Recommendation Report for Planning Permission for Works or Extension to a Dwelling

REF NO: AW/46/22/HH

LOCATION: 53 Gossamer Lane
Aldwick
PO21 3DD

PROPOSAL: Single storey rear extension.

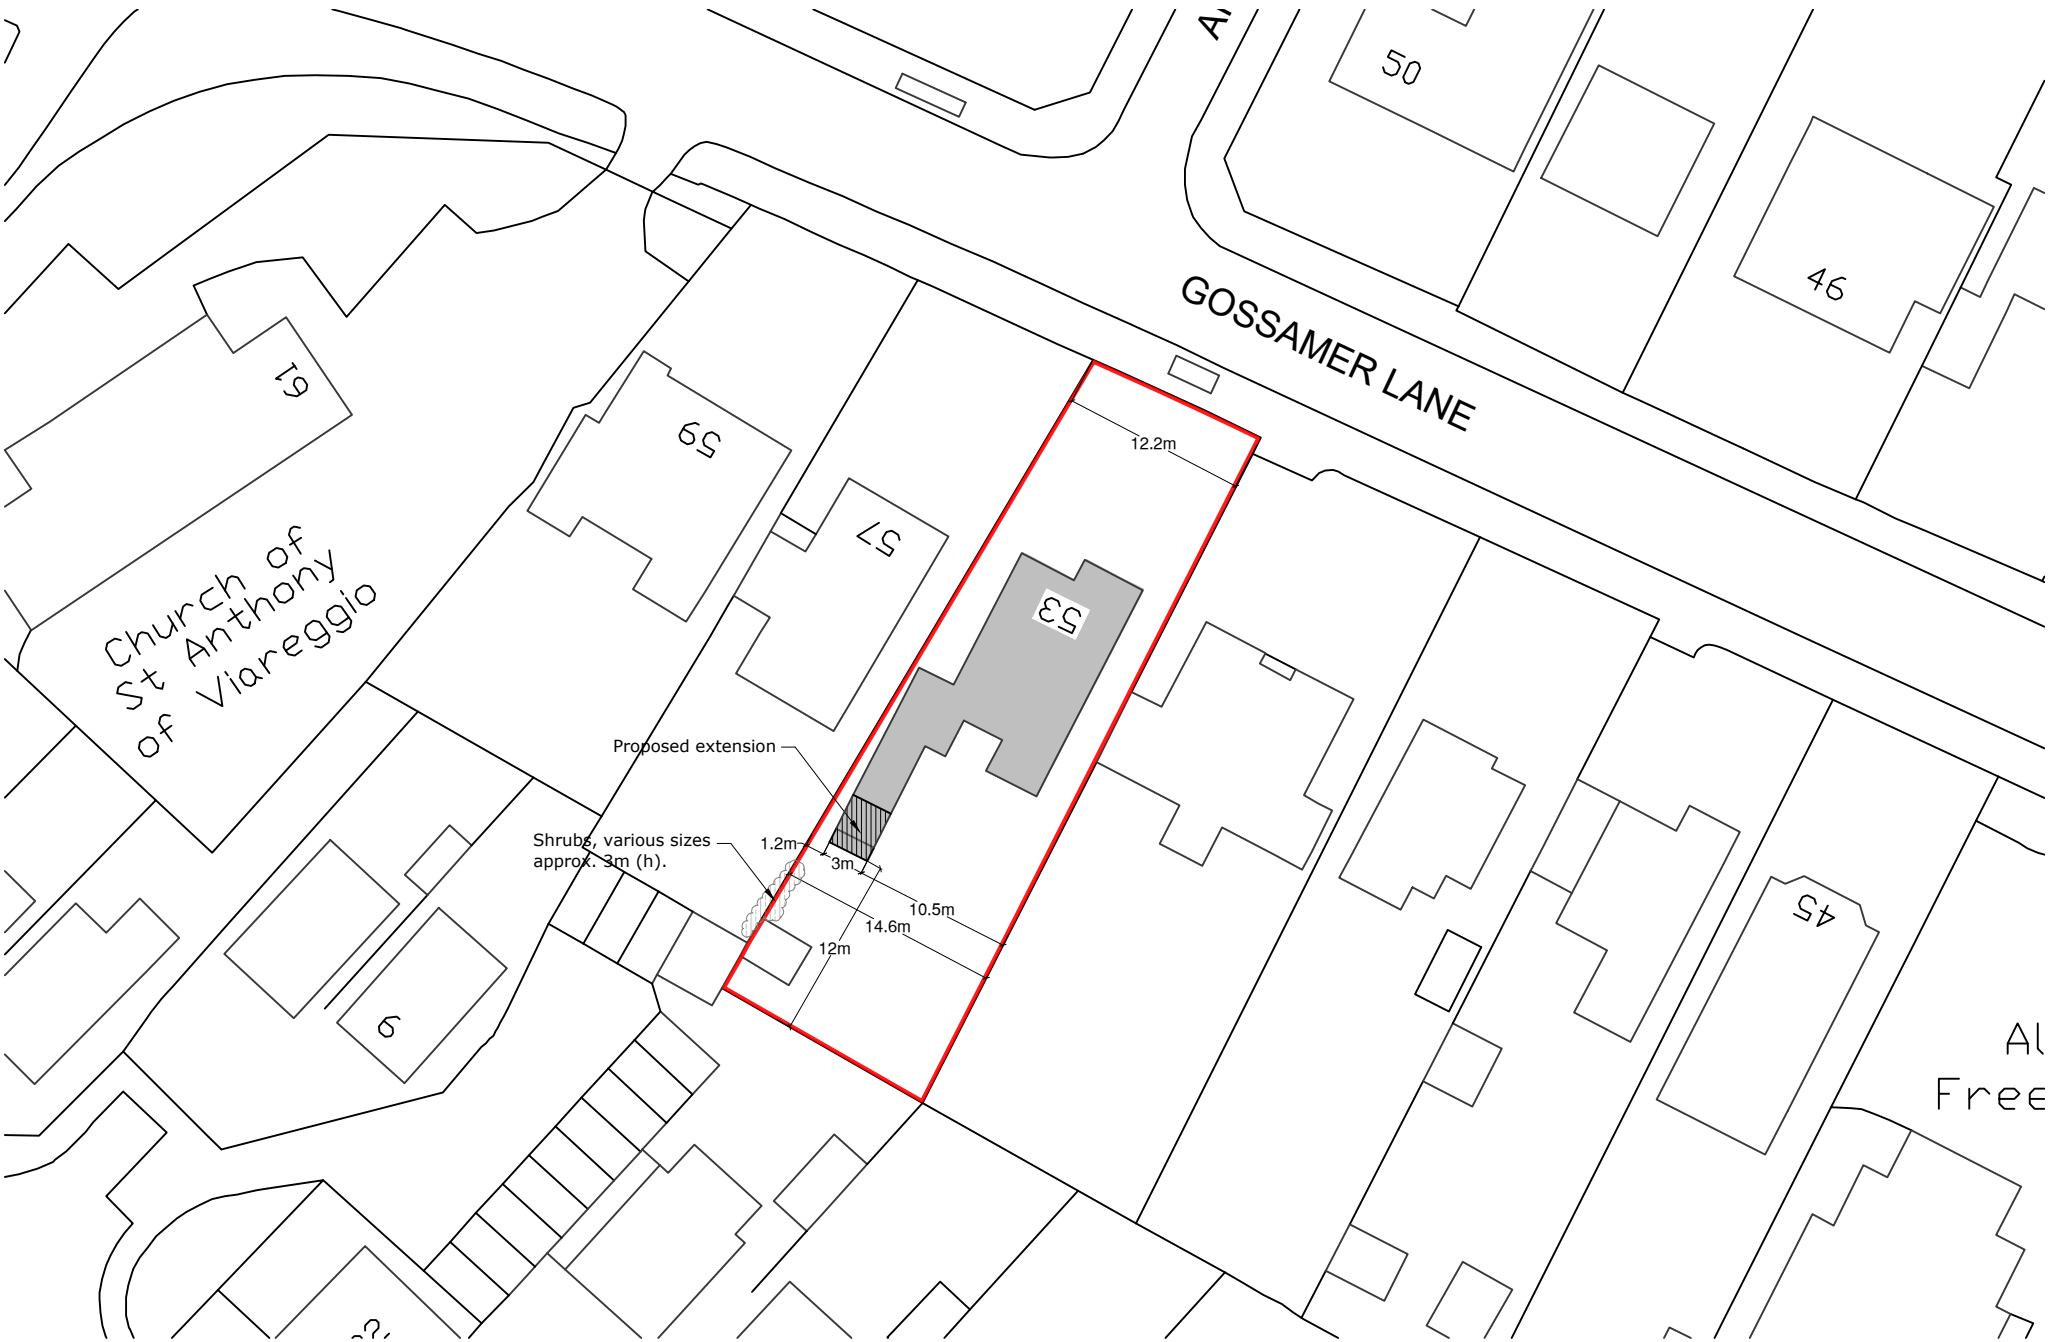
The Arun Design Guide states extensions should respond to and complement the existing character and appearance of the building and wider townscape in terms of scale, massing, materials, openings and roof form, and preserves external garden amenity space to at least 10.5m depth, and retains permeable surfaces. The proposal complies with the above, being in keeping with the scale and massing of the development on site. 12m is also retained to the rear boundary line.

A	20-02-2022	Planning issue	CE
REV	DATE	AMENDMENT	BY
PROJECT	53 GOSSAMER LANE ALDWICK WEST SUSSEX, PO21 3DD		
DRAWING	PROPOSED ELEVATIONS SINGLE STOREY REAR EXTENSION		
Date	FEBRUARY 2022	Drawn By	CE
Scale	1: 50 @A1	Iss. App. By	SK
Drawing No	008A	File Location	093

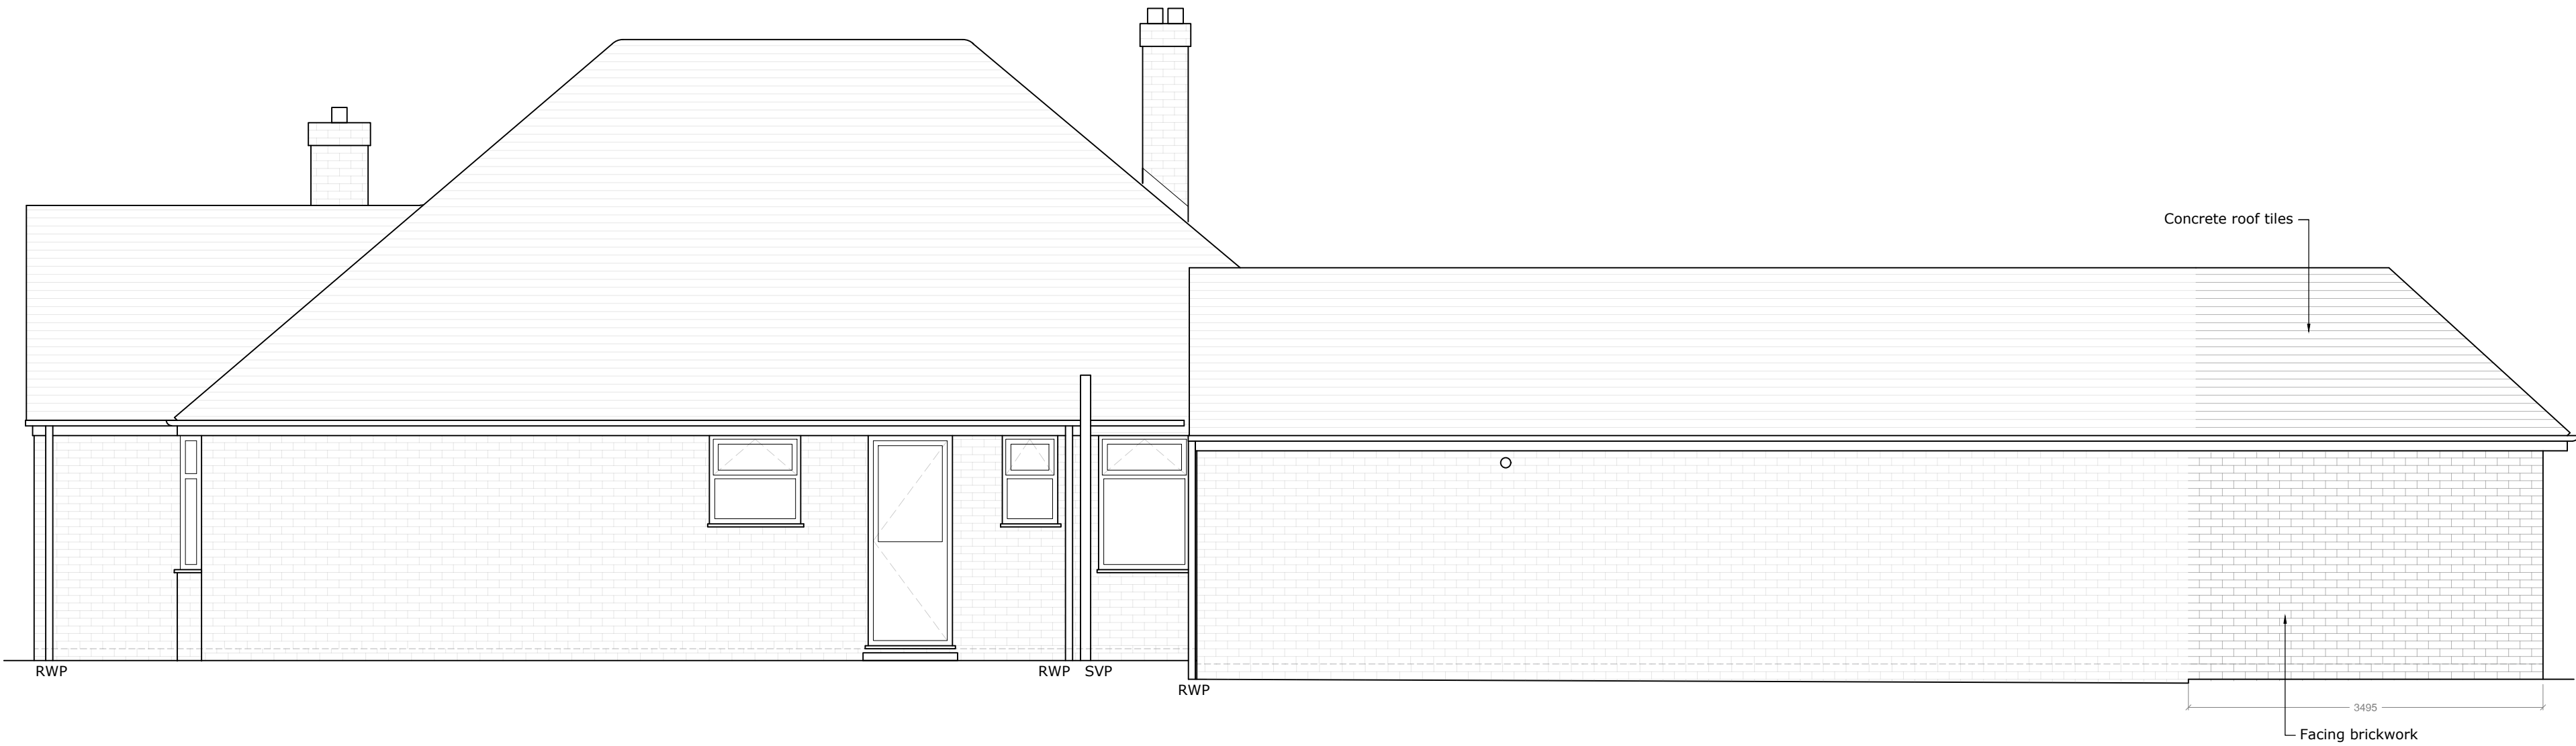
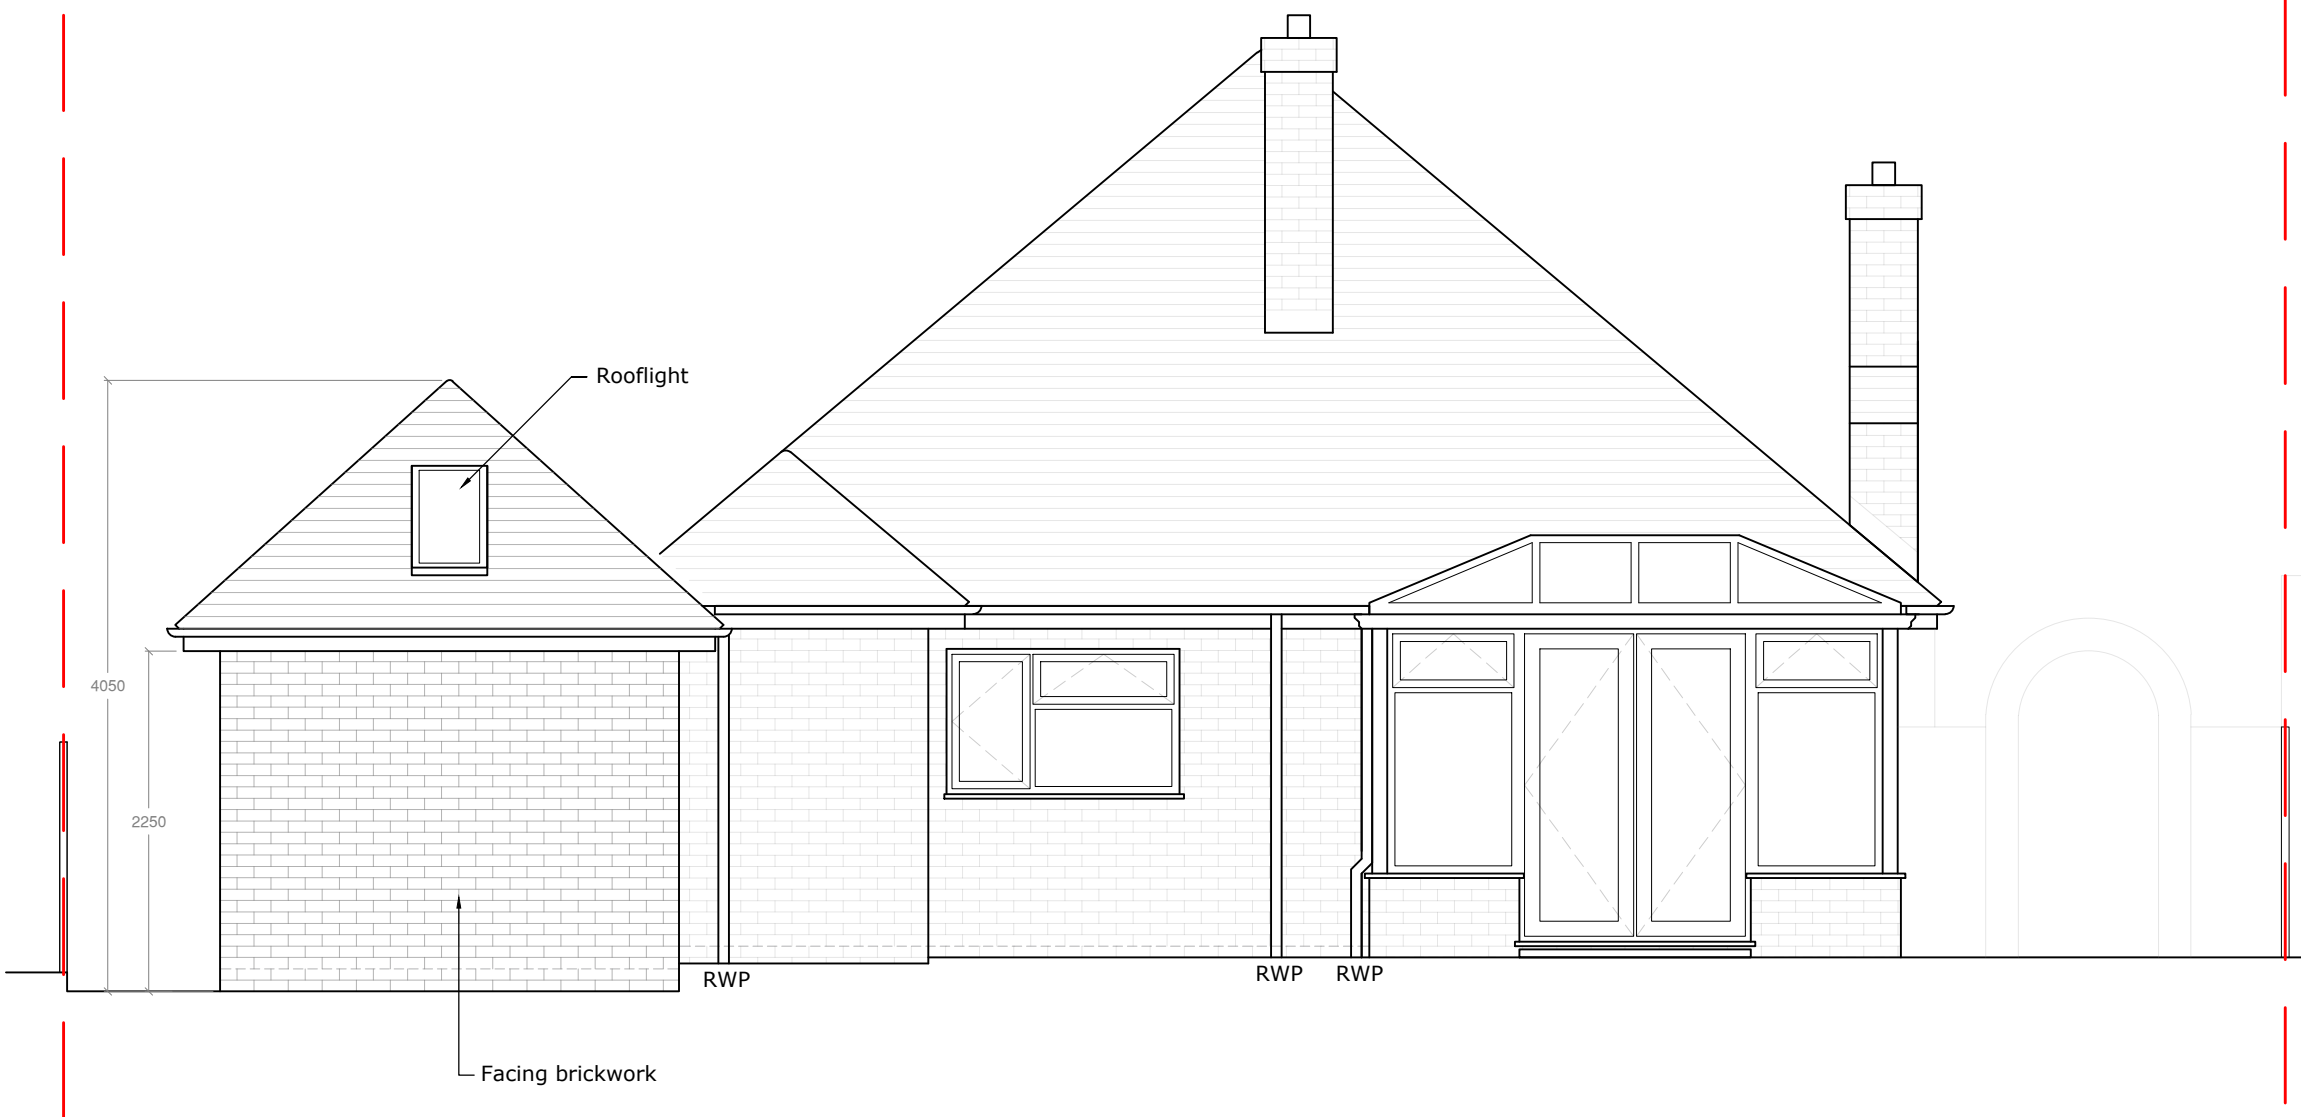
This appears well integrated with the dwelling and is appropriate in scale and massing. The roofline will extend in line with the ridge of the extension it joins with. The proposal will extend slightly further than the existing conservatory, but this is marginal and as such insignificant.

It will have a height of 4.05m with eaves to 2.25m with a hipped roof. This slopes away from the boundary and therefore reduces any overbearing impact.

The extension will feature doors to the eastern side elevation which will provide views over the garden of the host dwelling. There will be also be a rooflight although due to the height above finished floor, the development will not give rise to adverse overlooking.
